From: Contact Centre (CRM) <contact@ribblevalley.gov.uk>
Sent: 22 May 2026 11:35
To: Planning
Subject: Planning Application Comments - 3/2025/0688 FS-Case-840219315

Planning Application Reference No.: 3/2025/0688

Address of Development: Units 1-21 Mitton Road Business Park

Client <b>A I Land Ltd</b>		
Project <b>Proposed Alterations to Phase I Entrance at Mitton Road Business Park Whalley</b>		
Drawing Title <b>Existing and Proposed Site Plans</b>		
Scale <b>1:500 @ A2</b>	Date <b>Aug 2025</b>	Drawn <b>LFR</b>
<b>READ DESIGN LTD</b>		
<b>102 - 09 G</b>

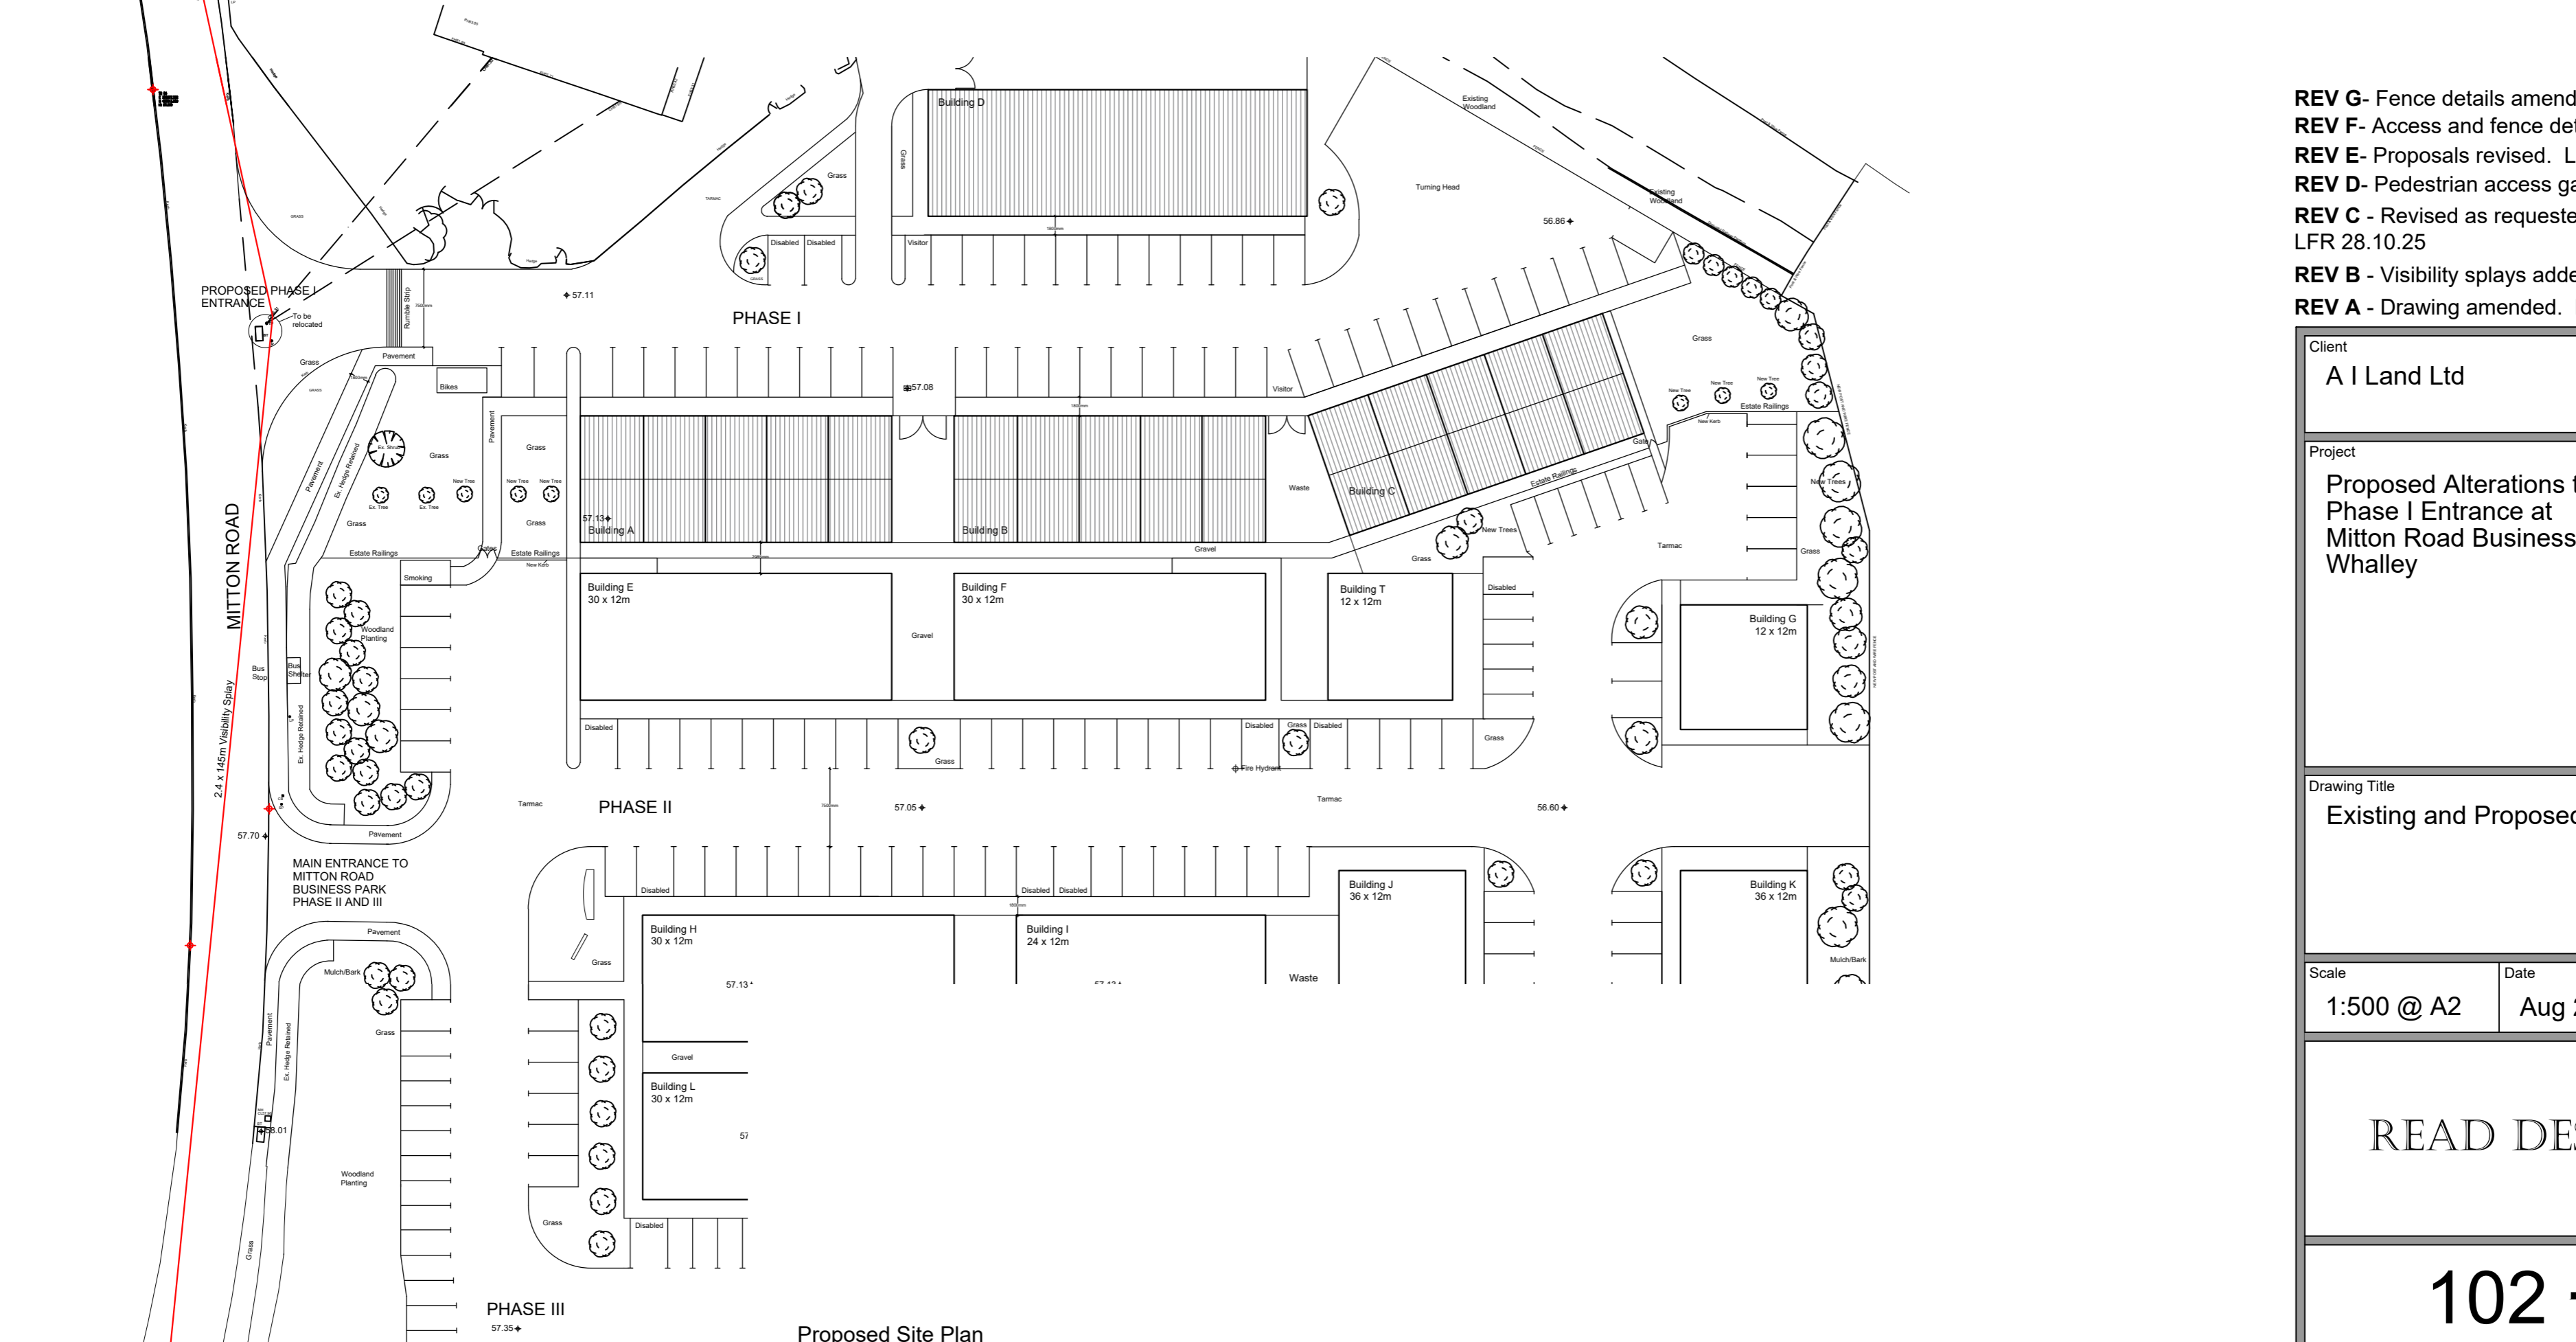
1. The plans that have been submitted showing the site now and plans for changes are incorrect, the plan that shows the site lay out now is incorrect, please see the photos and highlighted areas that are incorrect and show the site as it is.

A. Unit 16-21. [REDACTED] there is a large extension missing from the plans?

B. Single access road that is on both plans to unit. From phase 1 road to the back of unit. And parking at the [REDACTED] not exist it's on all plans but never installed.

C. Both plans also show some sort of fence divide between the single access to the rear of unit 16-21 and the parking area.
